**WEST SUSSEX COUNTY COUNCIL
STRATEGIC PLANNING CONSULTATION**

SUBJECT: EP/111/12 - Demolish 1 house (60 Sea Lane); partially demolish 1 house (45 The Ridings); construct 3 detached houses; alterations and extensions (45 The Ridings).

45 The Ridings, 60-62, Sea Lane, East Preston, West Sussex, BN16 2TW

PROPOSED SITE PLAN:
BASED ON TOPOGRAPHICAL SURVEY INFORMATION
SCALE 1:200

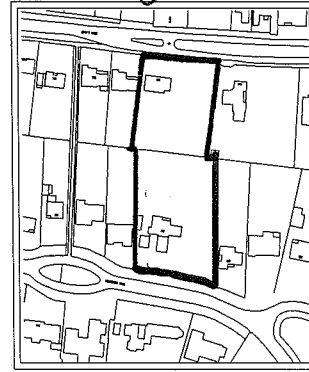
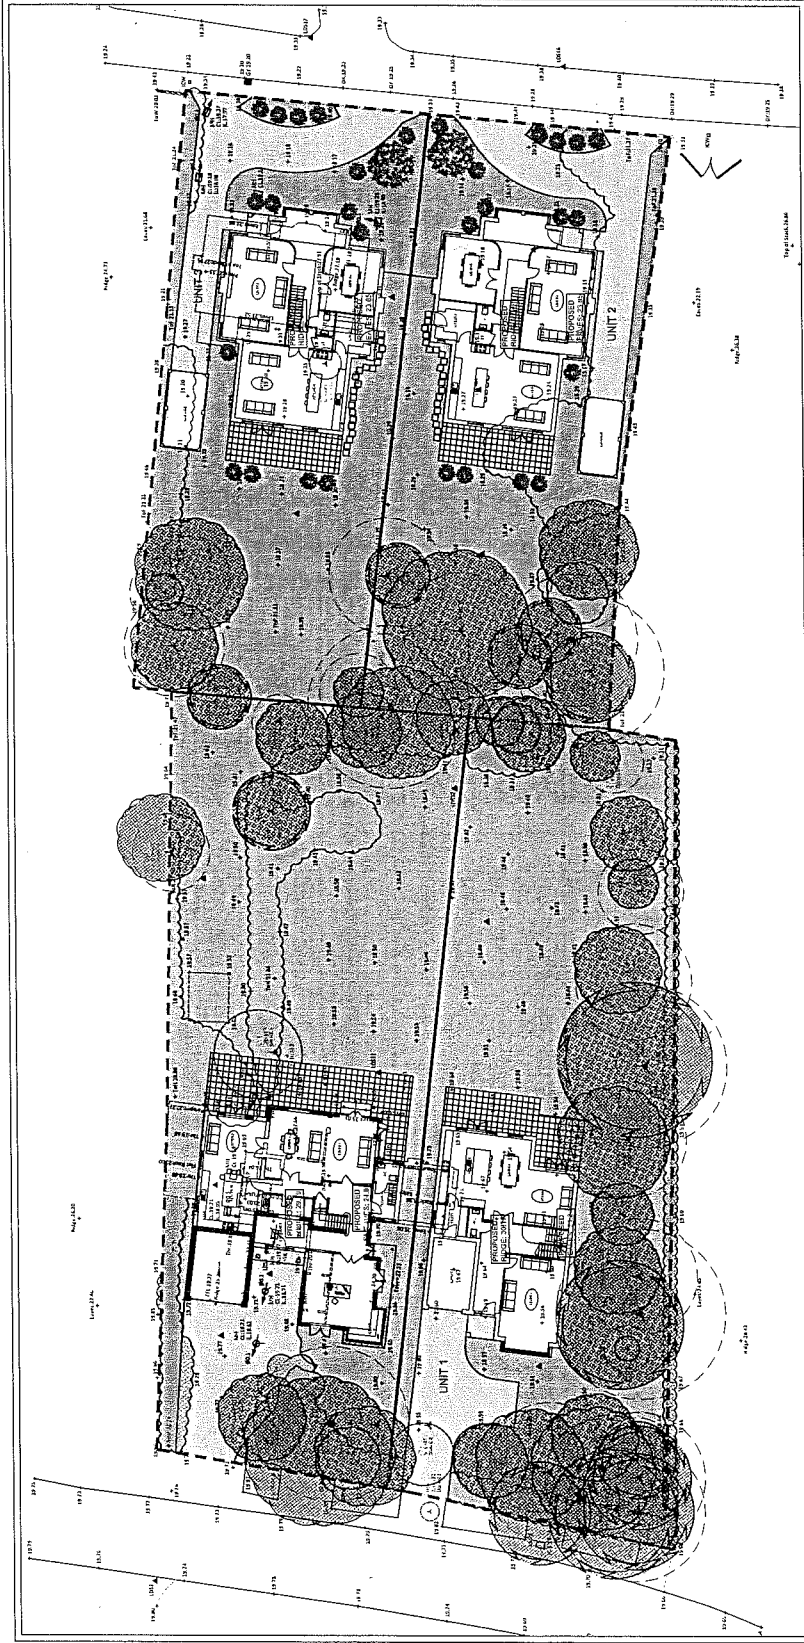
West Sussex County Council was consulted previously on Highway Matters for this location for this proposal. This is a re-consultation following a request for a modification for a turning area to be included on "Unit 2".

Further to the previous consultations on this proposal, the amended plans demonstrating the turning facilities for the properties accessed by Sea Lane are now acceptable to the Highway Authority subject to the following conditions.

Proposed dwellings accessed via Sea Lane only: No dwelling, hereby approved, shall be occupied until visibility splays of 2.4 metres by 43 metres have been provided at the centre of the proposed site vehicular access onto Sea Lane in a southerly direction only. These visibility splays shall thereafter be kept free of all obstructions over a height of 0.6 metres above adjoining carriageway level.

Proposed dwellings accessed via Sea Lane only: No dwelling, hereby approved, shall be occupied until the vehicle turning space has been constructed within the site in accordance with the approved site plan. These spaces shall thereafter be retained at all times for their designated use.
